**Application: SSI 7485**

I write regarding the proposed modification to M4-M5 Link, Mod 2 The Crescent overpass and changes to pedestrian infrastructure in North Annandale, Rozelle and Rozelle Bay Foreshore area.

Figure 4-1 Overview of the proposed modification

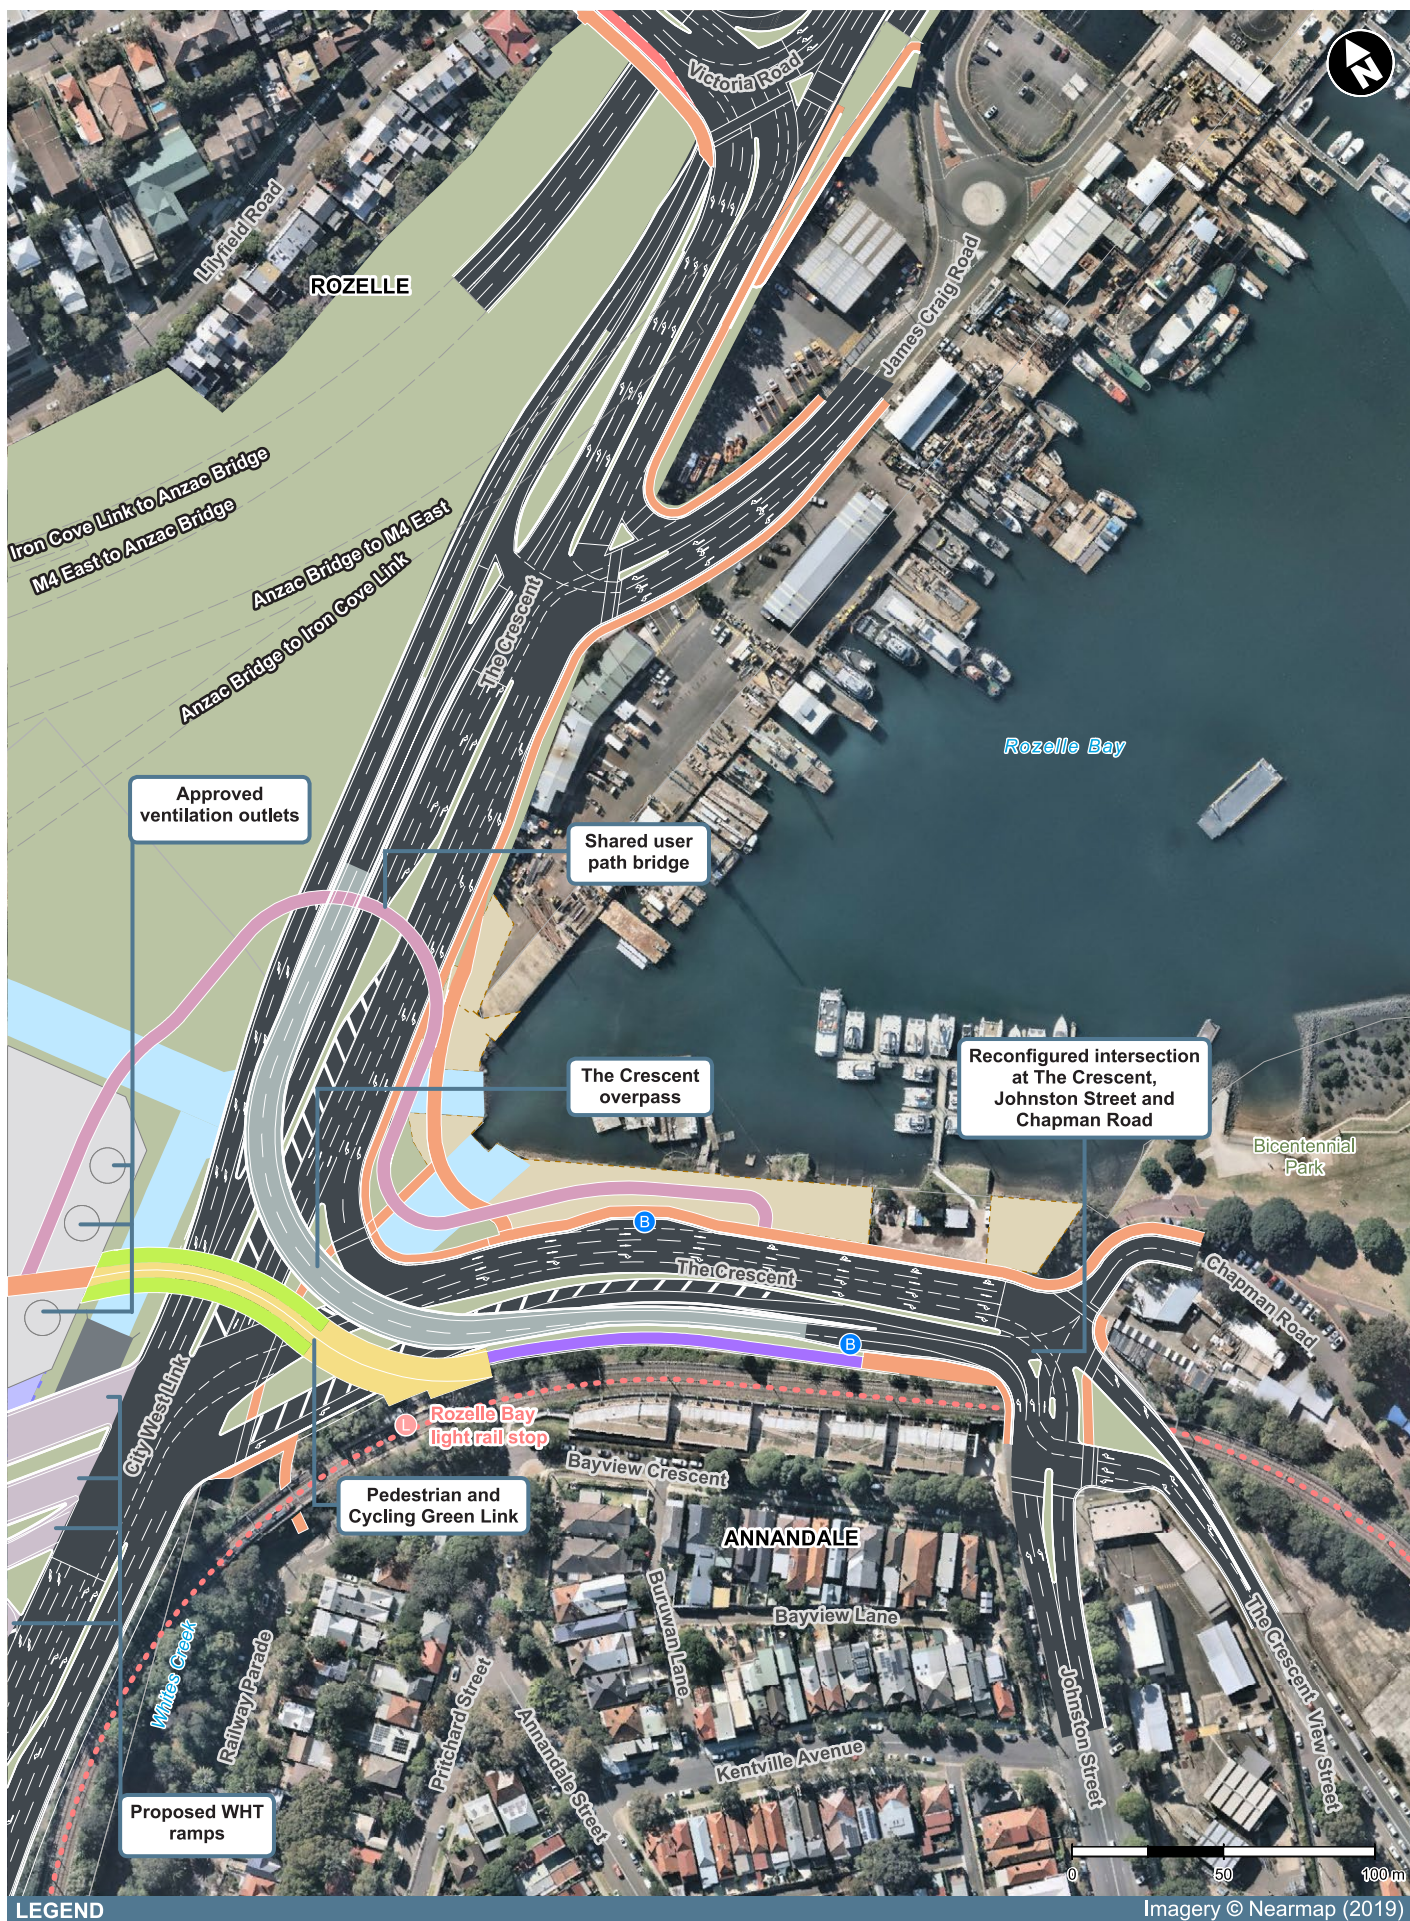
I write as a cyclist and pedestrian. As a cyclist I ride from Lilyfield to the University of Sydney daily, via the Rozelle Bay light rail and the Crescent. The proposed modification adds rather than subtracts traffic lights from my journey, and from my reading of the not very clear maps actually makes it impossibly dangerous to head east as a cyclist on The Crescent. This is deplorable in a city where cycling needs to be encouraged rather than discouraged.

The proposed changes also make it almost impossible for me to access the foreshore and Bicentennial Park as a pedestrian, either from Lilyfield/Brenan Street or via the pedestrian overbridge at Victoria Rd.
